# KIRKLEES METROPOLITAN COUNCIL INVESTMENT & REGENERATION SERVICE

| Reference No:         | <b>2023/62/93683/E</b>                                                                                                                         |
| Site Address:         | Hill Crest, The Village, Thurstonland, Huddersfield, HD4 6XX                                                                                   |
| Description:          | Erection of first floor extension with front porch, rear dormers and associated internal and external alterations (within a Conservation Area) |

DRAWING DESCRIPTION  
PLANS & ELEVATIONS AS PROPOSED  
OPTION D

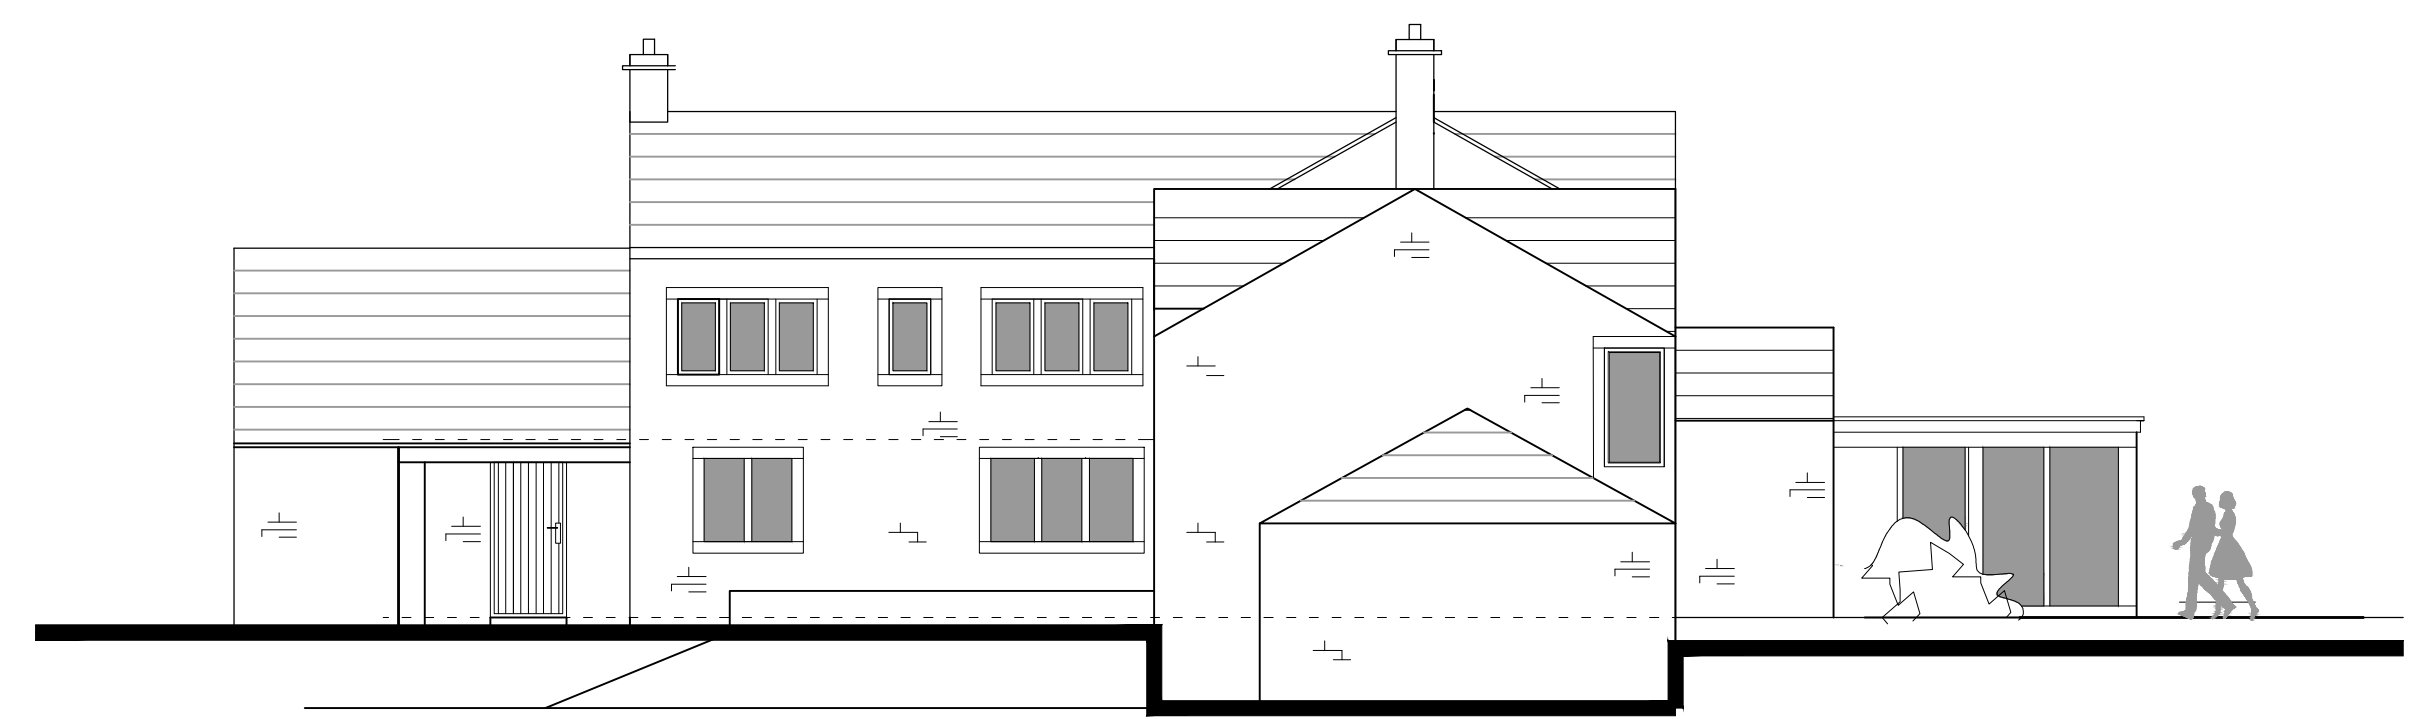
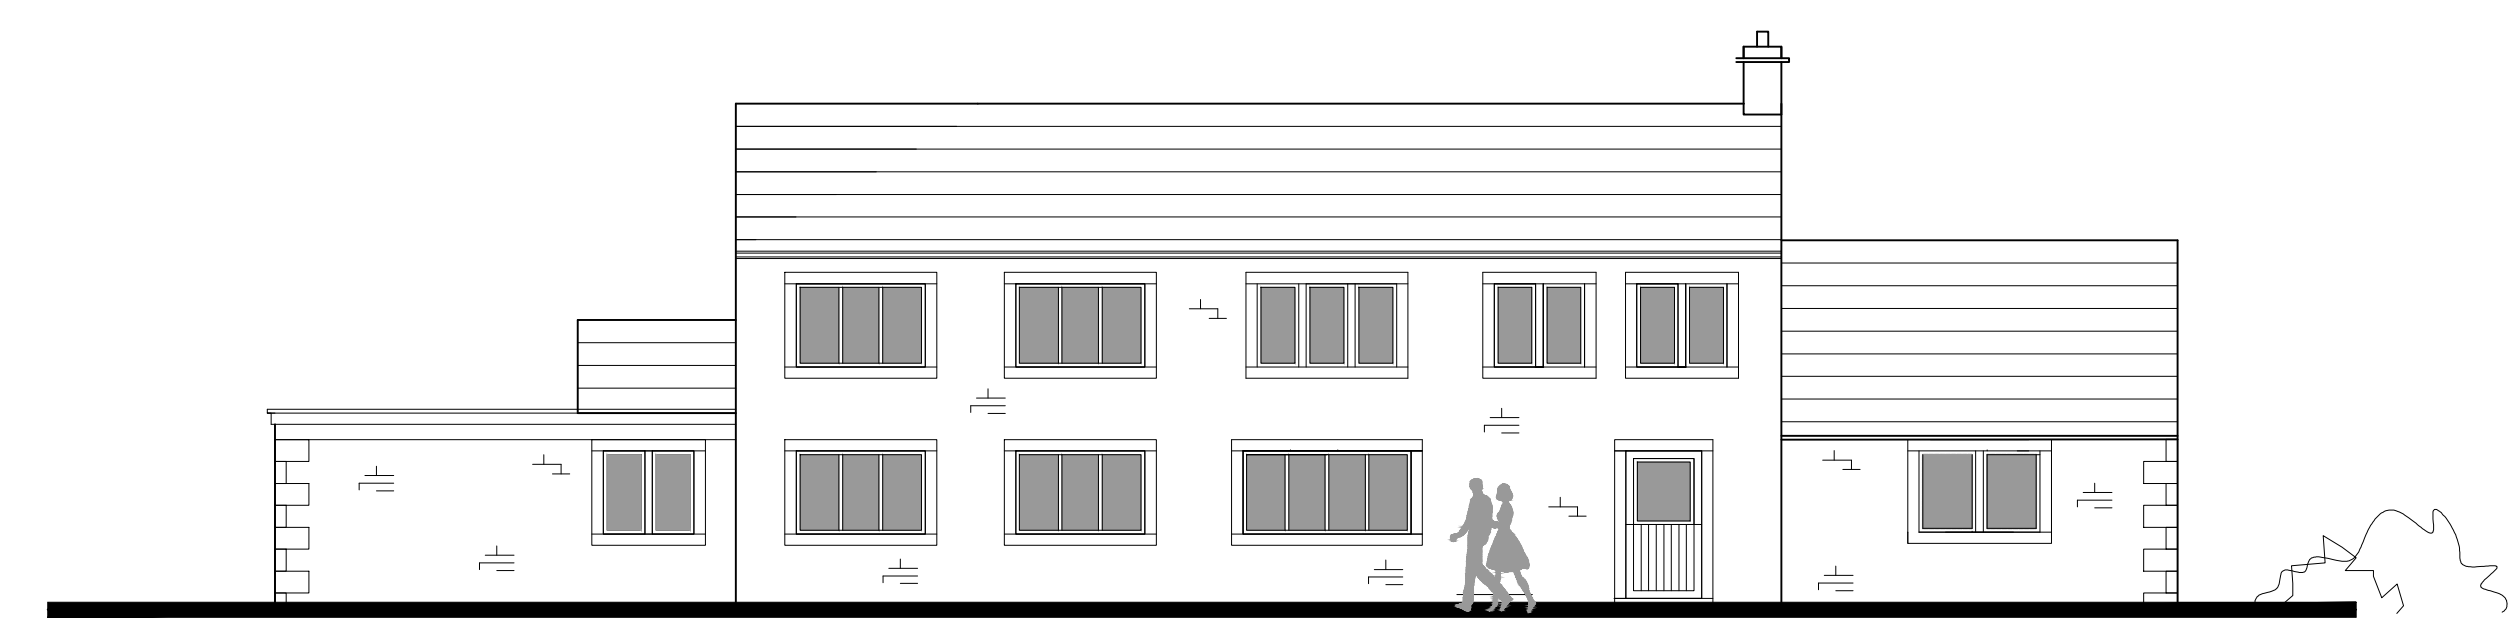
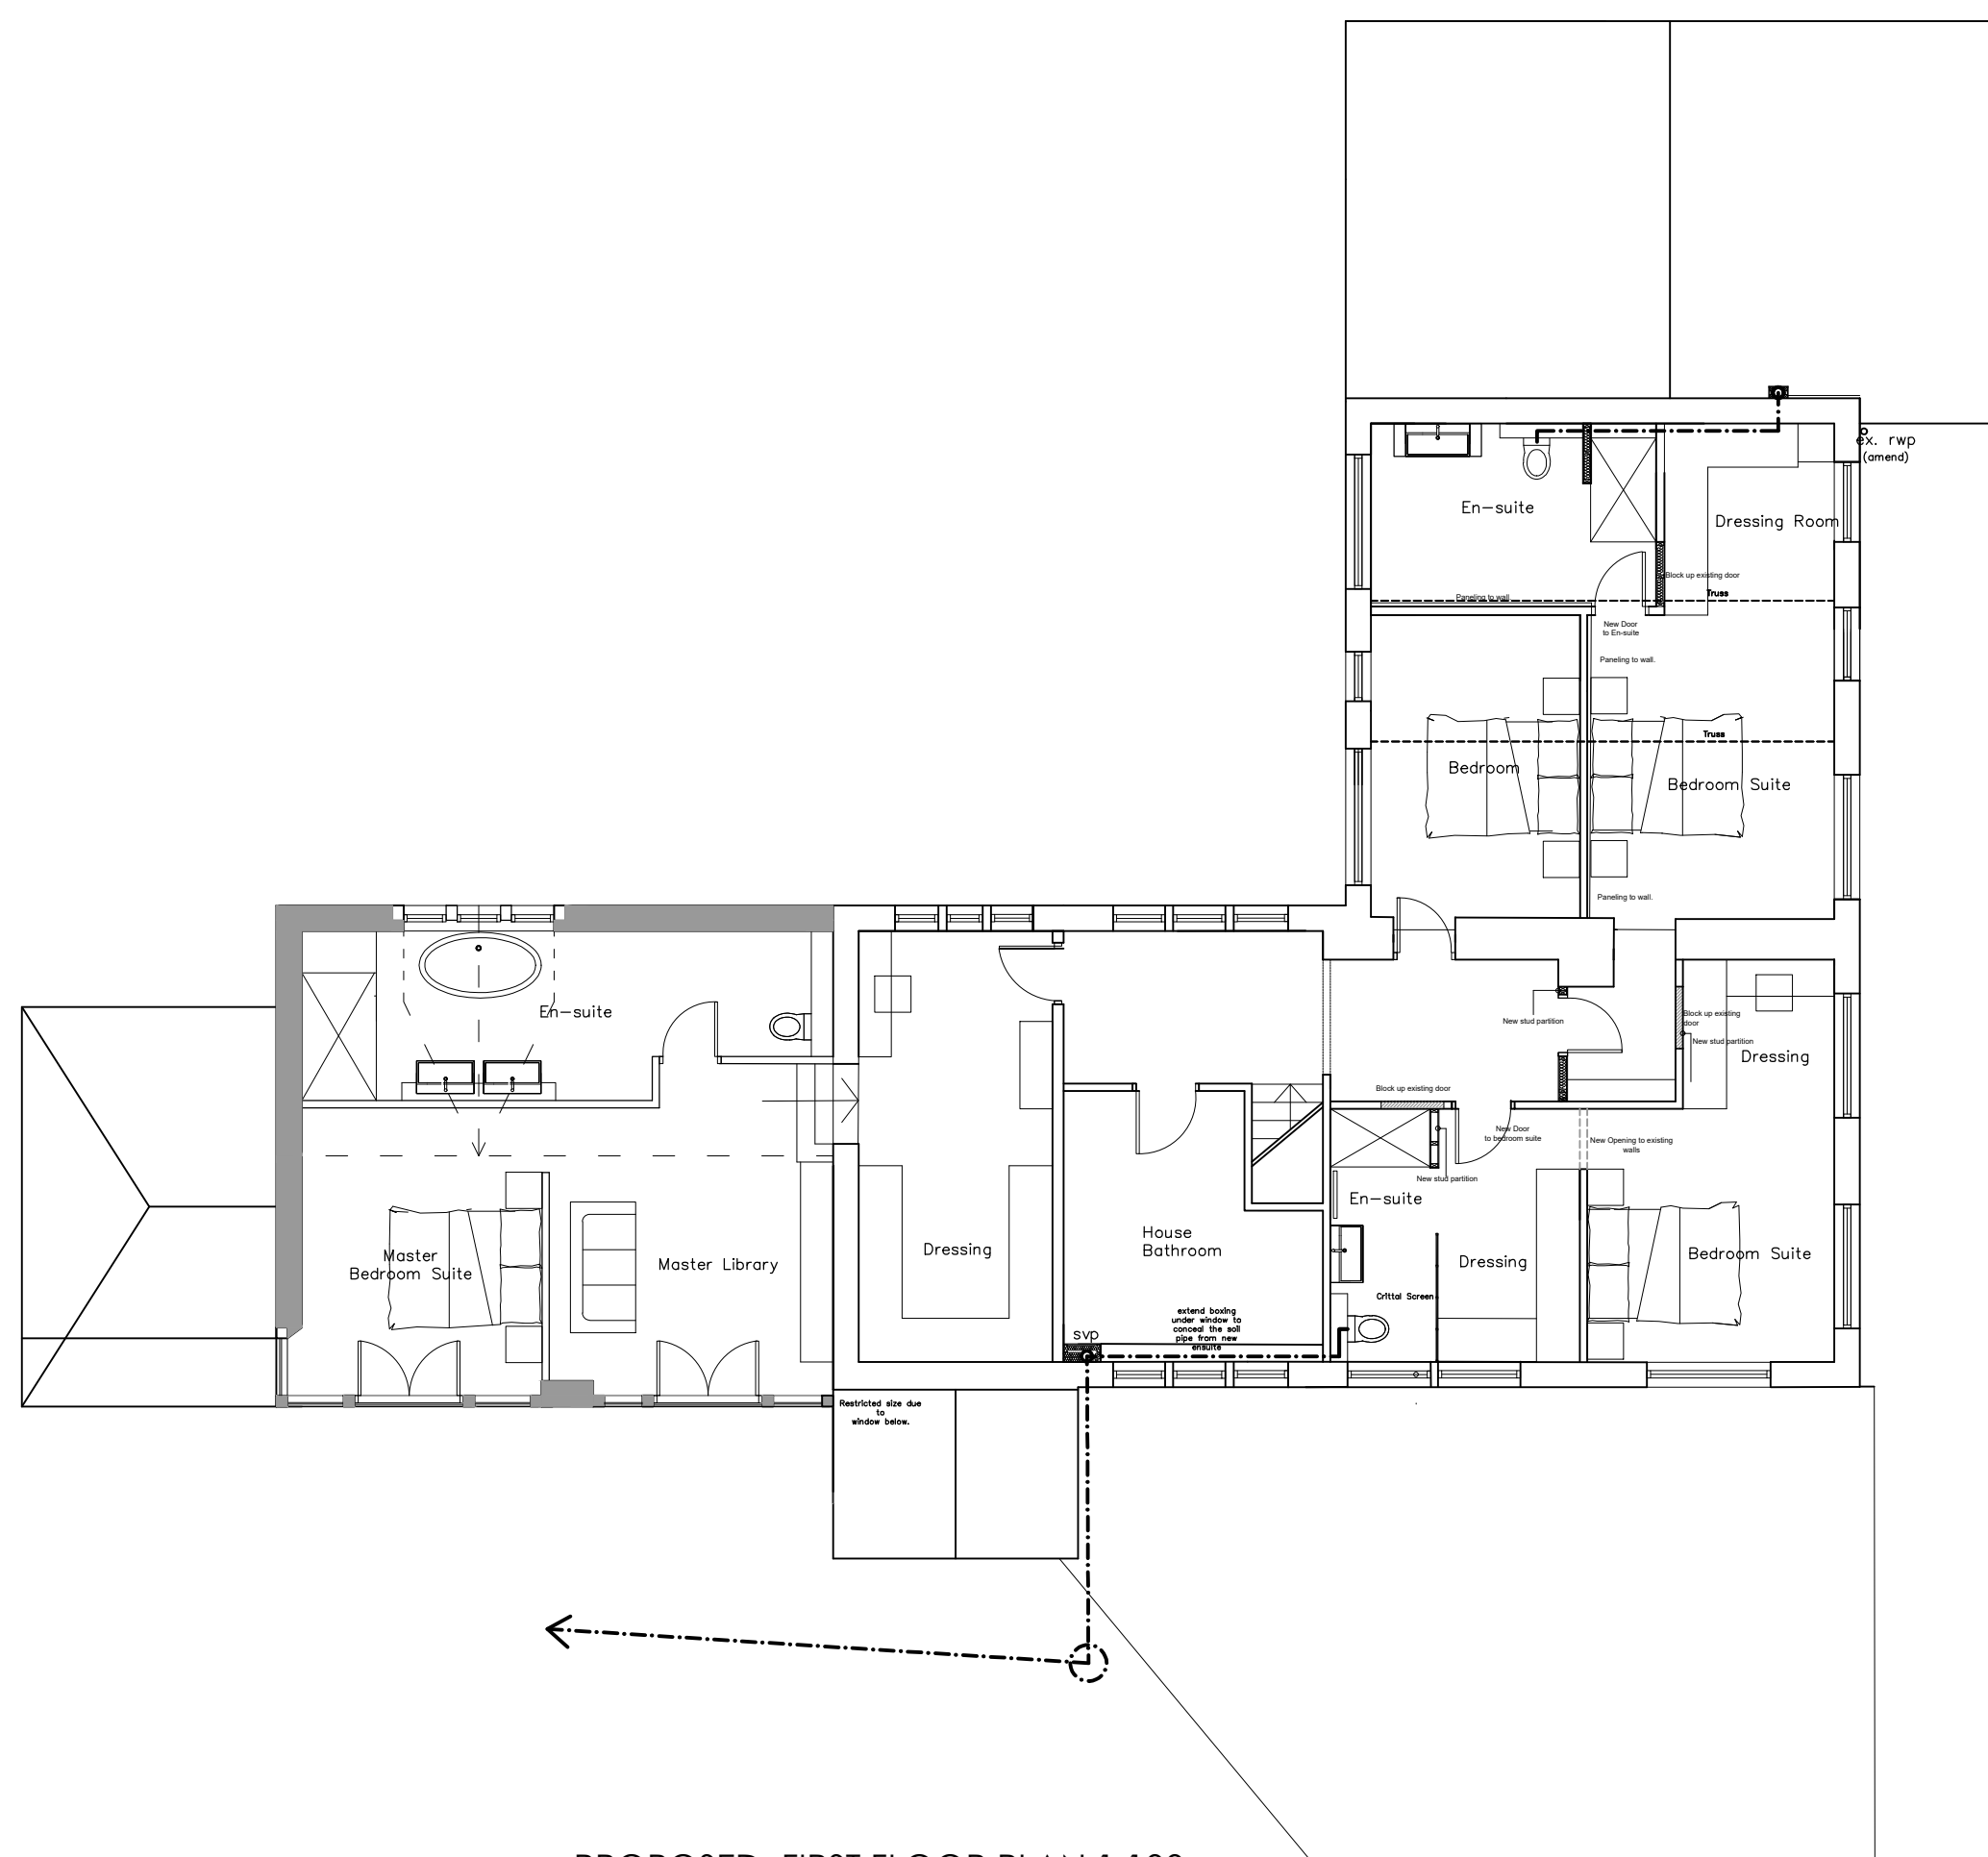
KC Conservation & Design – Conservation & Design were consulted as the site is within a conservation area and sits behind grade II listed buildings. Initially, there were concerns with the design as it included a front elevation dormer. Amended plans were requested to replace the dormer with mullion windows as to not disrupt the frontage and setting of the conservation area and listed building. The amended plans were found to have a neutral impact to the setting of the conservation area and listed building.

Amended plans were requested to remove the dormer and include mullion windows on the front elevation.

The first-floor side extension is not set back from the front elevation, however it follows the building line of the dwelling which is an appropriate design consideration to retain its character. It is set down below the ridgeline of the original dwelling and has the appearance of being subservient. The extension is designed with a pitched roof which is consistent with the host dwelling and wider building group. Due to the layout of the building and site, there will be sufficient space retained to the side. The rear of the property currently has a high amount of glazing and is more modern in style. The addition of the dormers will therefore contribute to its appearance. As the dormers are set into the walls, they will blend into the dwelling and will not be visible from the front of the property.
